From: [Justin Turnbull](#)
To: [Zach Torrance-Smith](#)
Cc: [Jamey Ayling](#)
Subject: RE: SX-23-00017
Date: Thursday, September 21, 2023 7:50:52 AM

From: Zach Torrance-Smith <zach.torrancesmith@co.kittitas.wa.us>
Sent: Wednesday, September 20, 2023 9:14 AM
To: Jason Adams <4soundconsulting@gmail.com>
Cc: Justin Turnbull <justin.turnbull@co.kittitas.wa.us>
Subject: RE: SX-23-00017

SITE PLAN

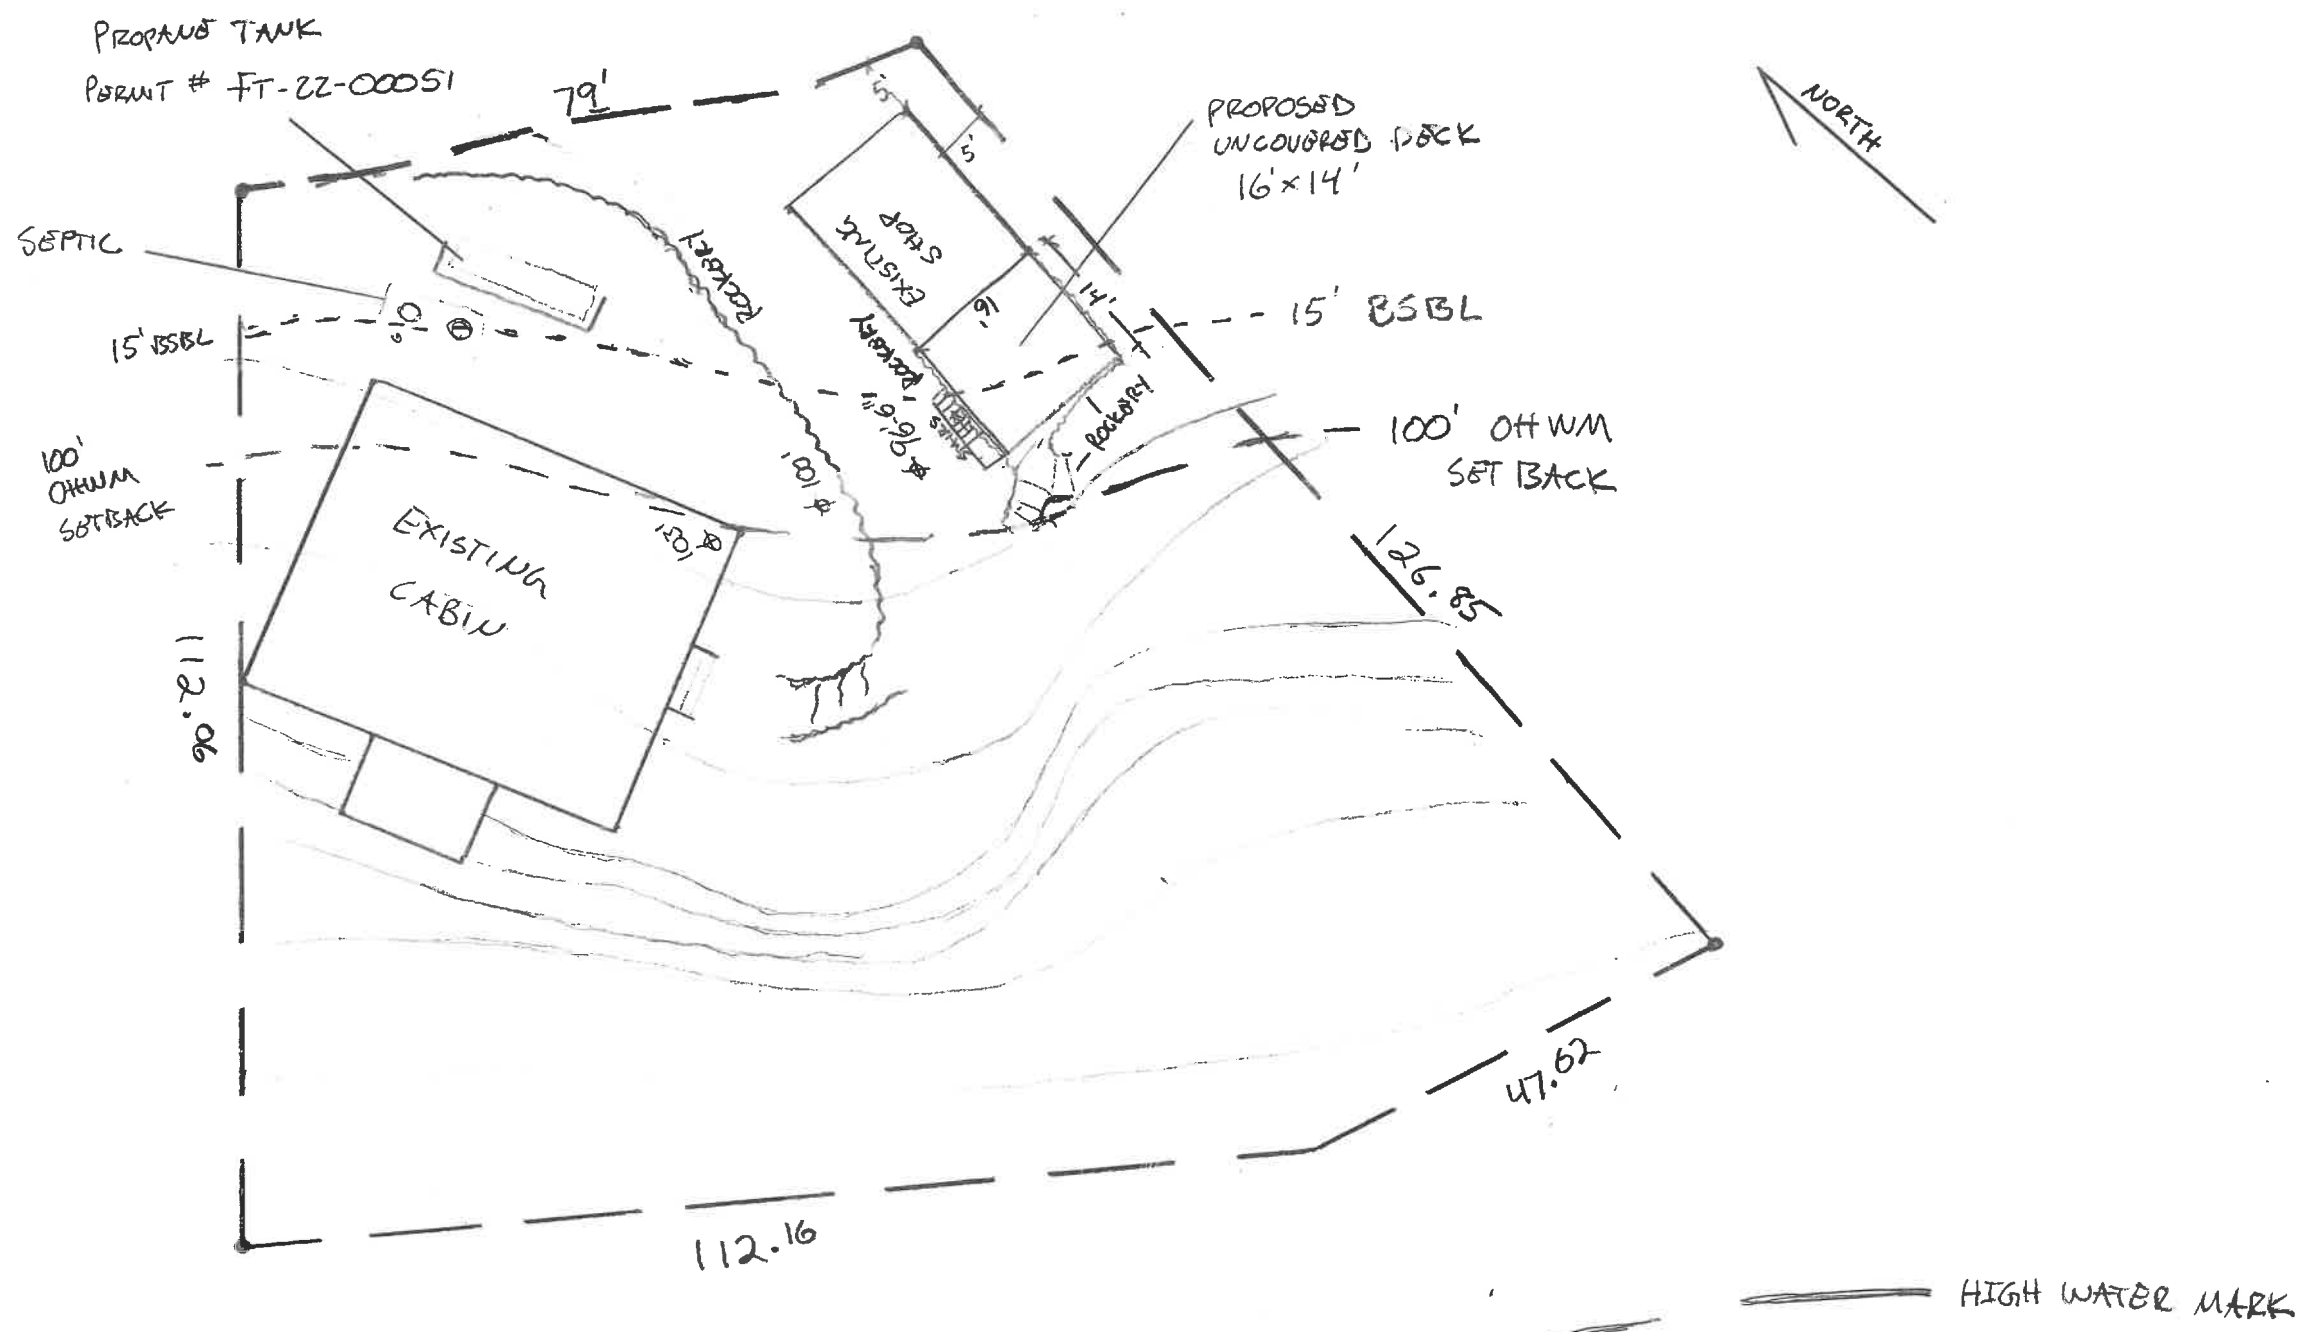
My comments were more in regards to the County intake process which clearly lists the items I noted as missing from the application. The fact that we are missing these elements and still accepted the application puts additional burden on the applicant, rather than addressing the deficiencies while they are here and at the front counter.

I am good with it if you are. It would probably be good to know he isn't going to put a deck over his septic field though.

I'm including our County Surveyor Justin Turnbull to help clarify what is needed to satisfy the Survey comments. Please note the Shoreline Exemption Permitting application form states the following: "Required Information/Attachments: A scaled site plan is required showing **location of all** structures (including decks), driveways/impervious surfaces, well, septic, propane tanks, fences, etc. and proposed uses and distances from property lines, river, and horizontal distance from Ordinary High Water Mark. To show the horizontal distance a profile view from the OHWM to the edge of structure/activity shall also be shown."

per survey's comments - I am not clear on what was provided on the site plan, is it the well specifically. Said well is not on our property, I showed the driveway, septic, all structures etc?
